Jeanette Mose Subdivision

A portion of the Southeast Quarter of Section 8, Township 12 South, Range 64 West of the 6th P.M., County of El Paso, State of Colorado.

Job No. 201005 JEANETTE MOSE SUB. DATE August 31, 2020

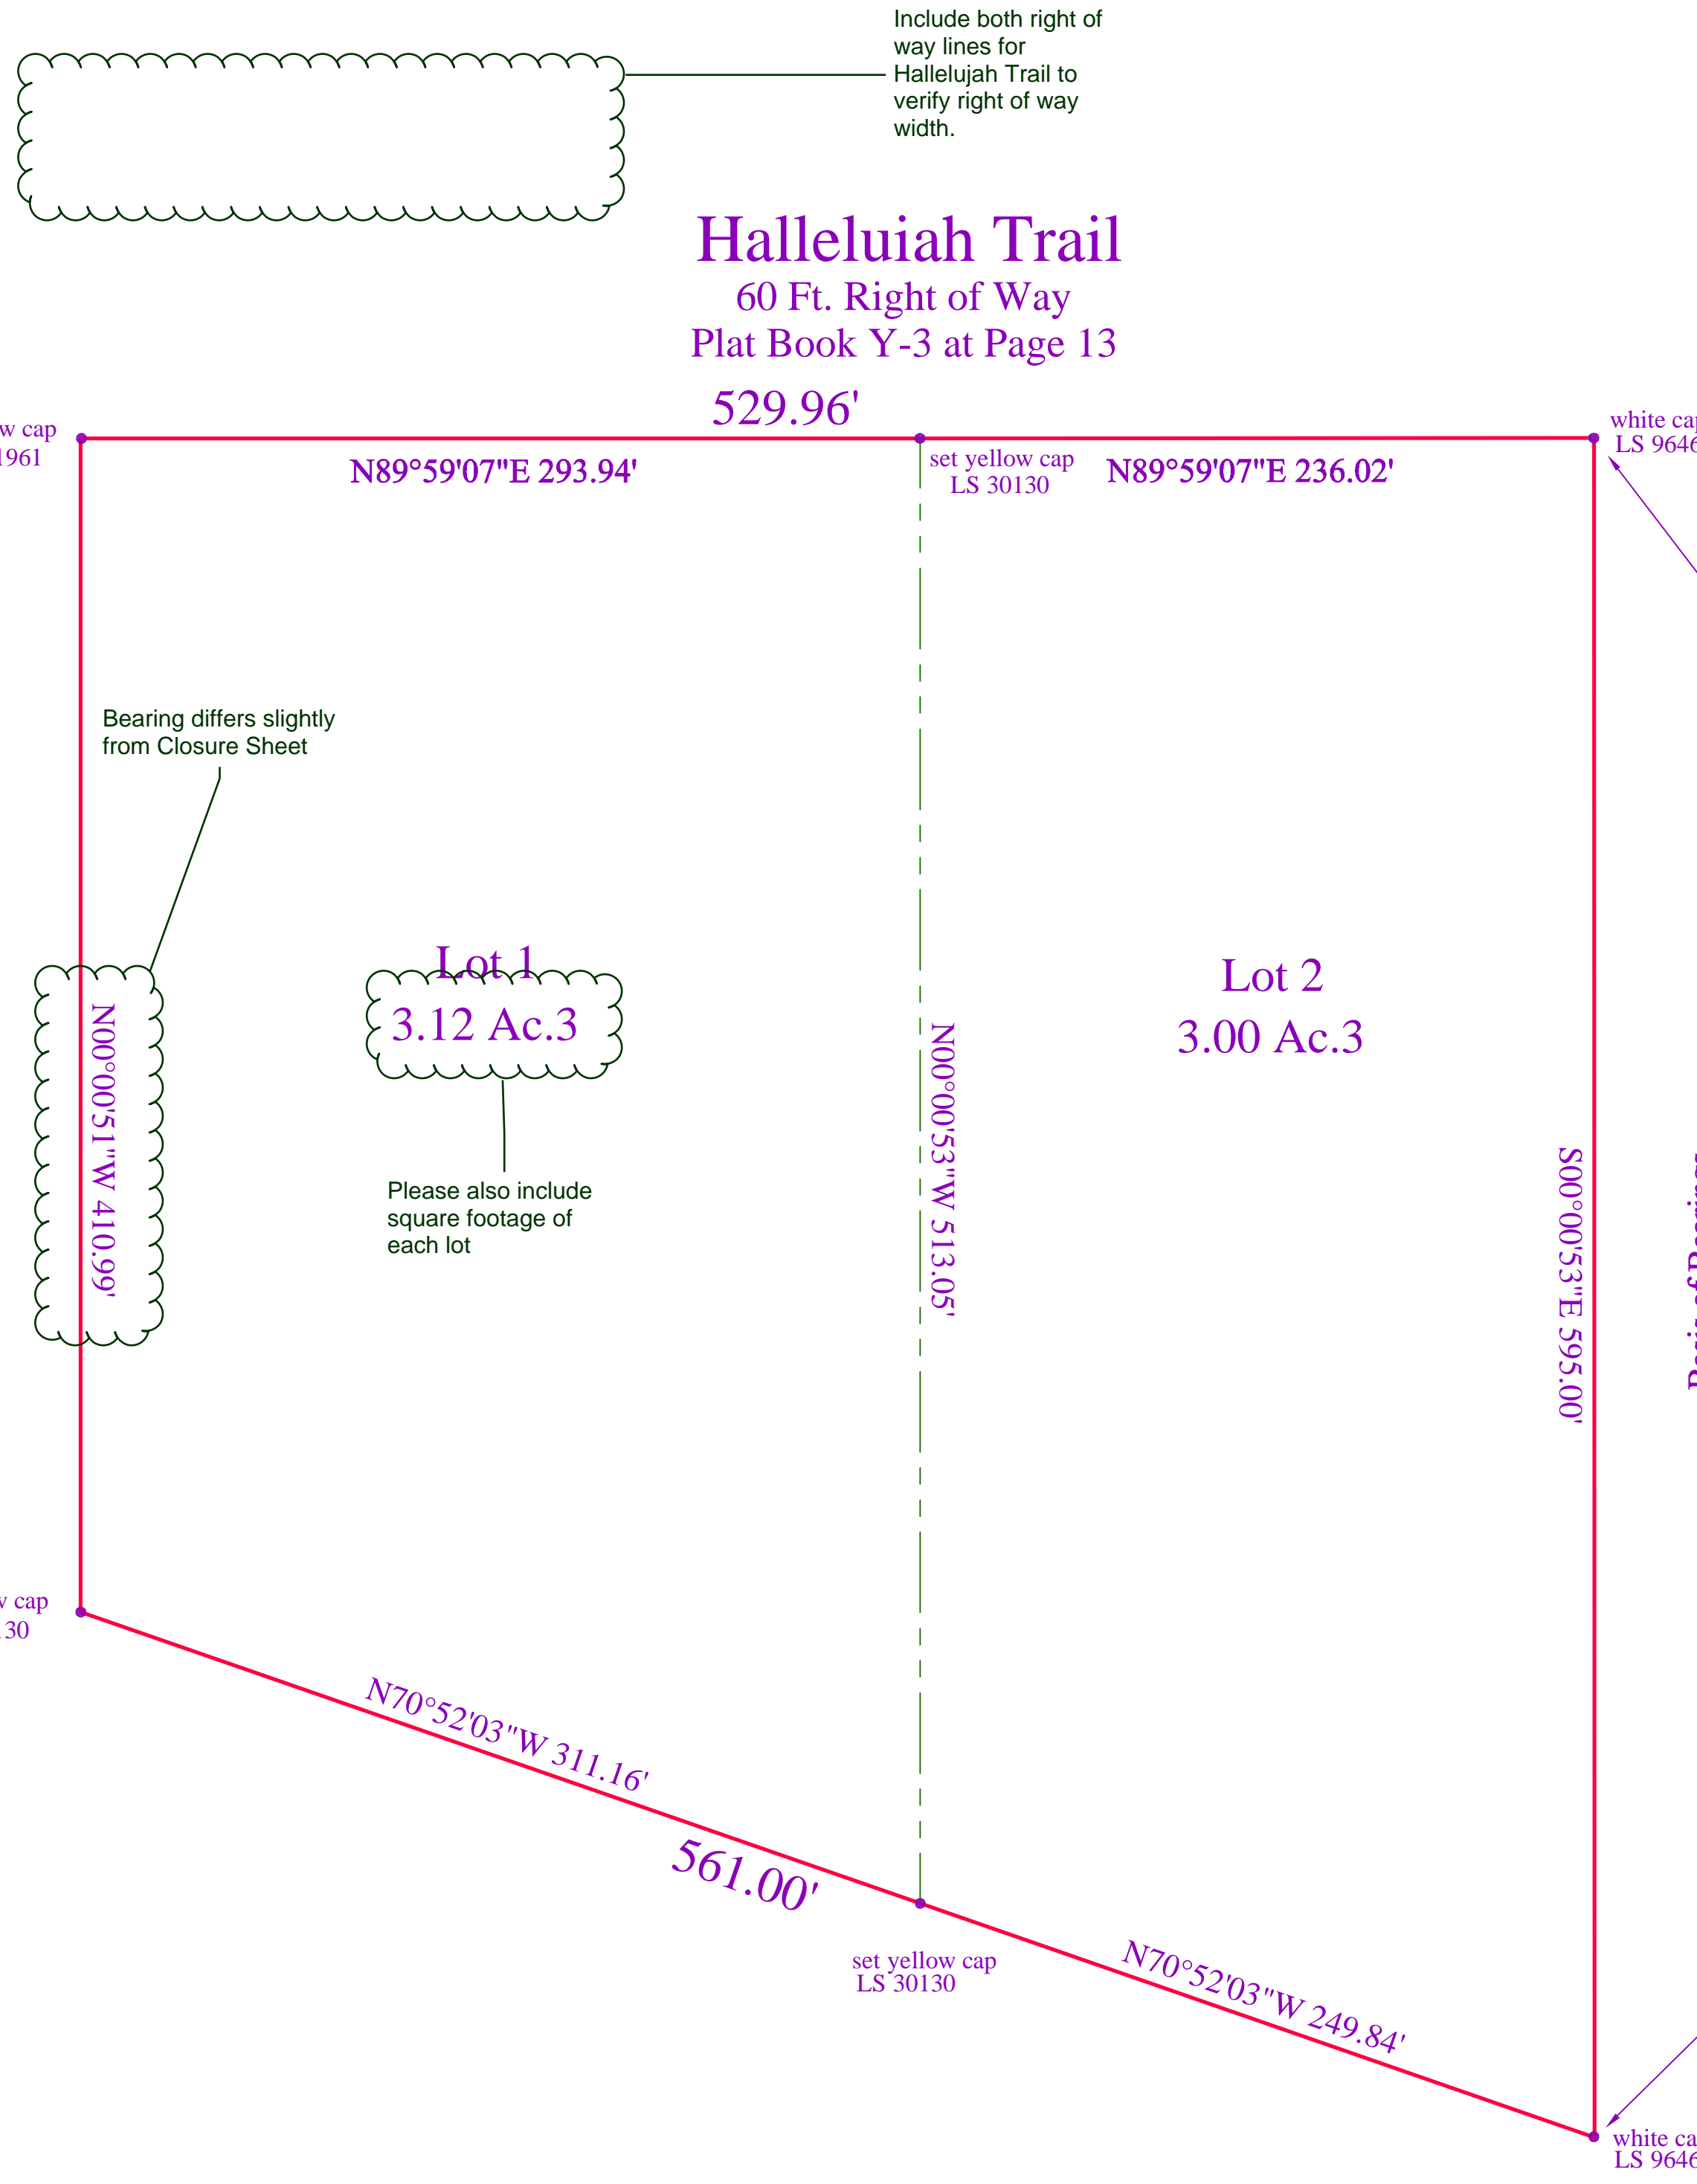
Update to show adjacent subdivisions and lots.

Update to add following notes to plat:

***Driveway Note:**
Individual lot purchasers are responsible for constructing driveways, including necessary drainage culverts from _____ Road per Land Development Code Section 6.3.3.C.2 and 6.3.3.C.3. Due to their length, some of the driveways will need to be specifically approved by the (name of Fire District).*

Revise to say "El Paso County Department of Public Works" instead of "El Paso County Department of Transportation"

Remove drainage report from note 11.

Remove note 16 since it does not apply to this plat.
